Ribble Valley Borough Council
Development Control

Application no: 3/2019/0921

Address: La127-129 Chatburn Road Clitheroe

Proposal: Demolition and rebuild of 127 Chatburn road and side extension to High Brake House Care Home

SHEET:  
HIGH BRAKE HOUSE EXISTING & PROPOSED SITE PLANS

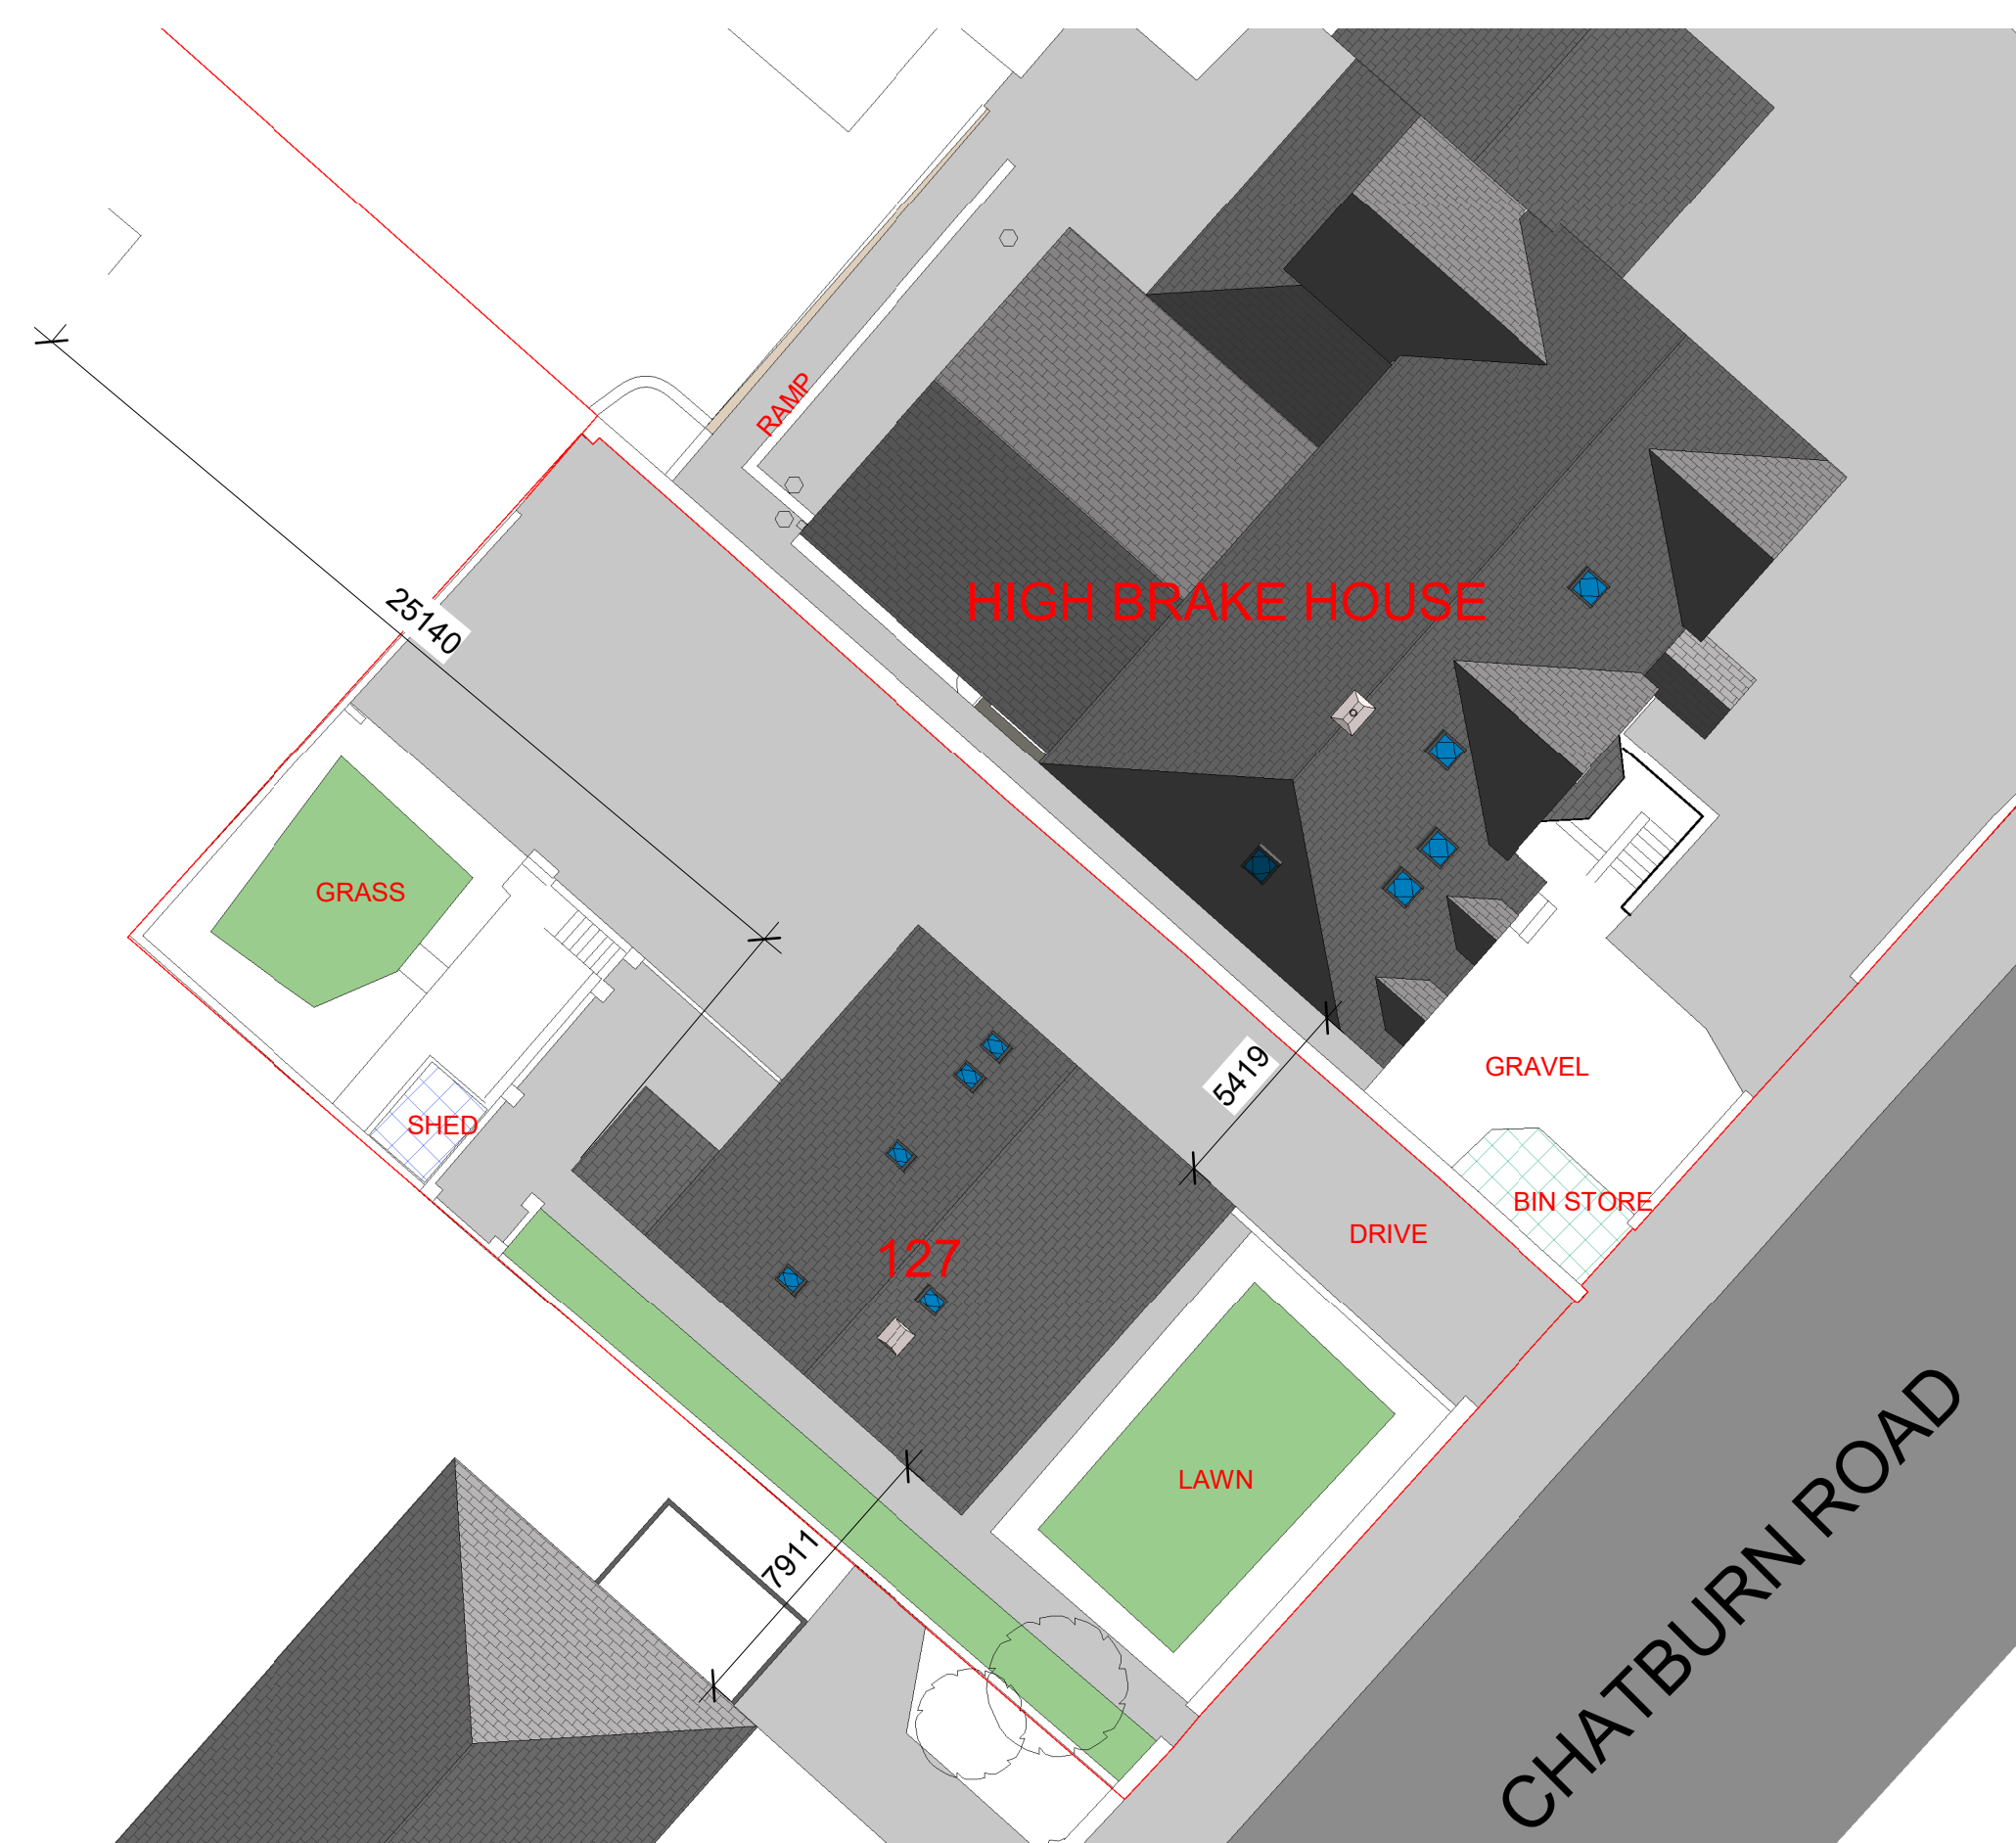
The reconstruction of 127 Chatburn Road will require the relocation of the existing vehicle access crossing which will become redundant therefore should your council be minded to approve this application I would request that the following conditions be attached to any planning permission that may be granted

1. The existing access shall be physically and permanently closed and the existing verge/footway and kerbing of the redundant vehicular crossing to 127 and 129 Chatburn Road shall be reinstated in accordance with the Lancashire County

Council Specification for Construction of Estate Roads concurrent with the formation of the new access.

Reason: To limit the number of access points to, and to maintain the proper construction of the highway.
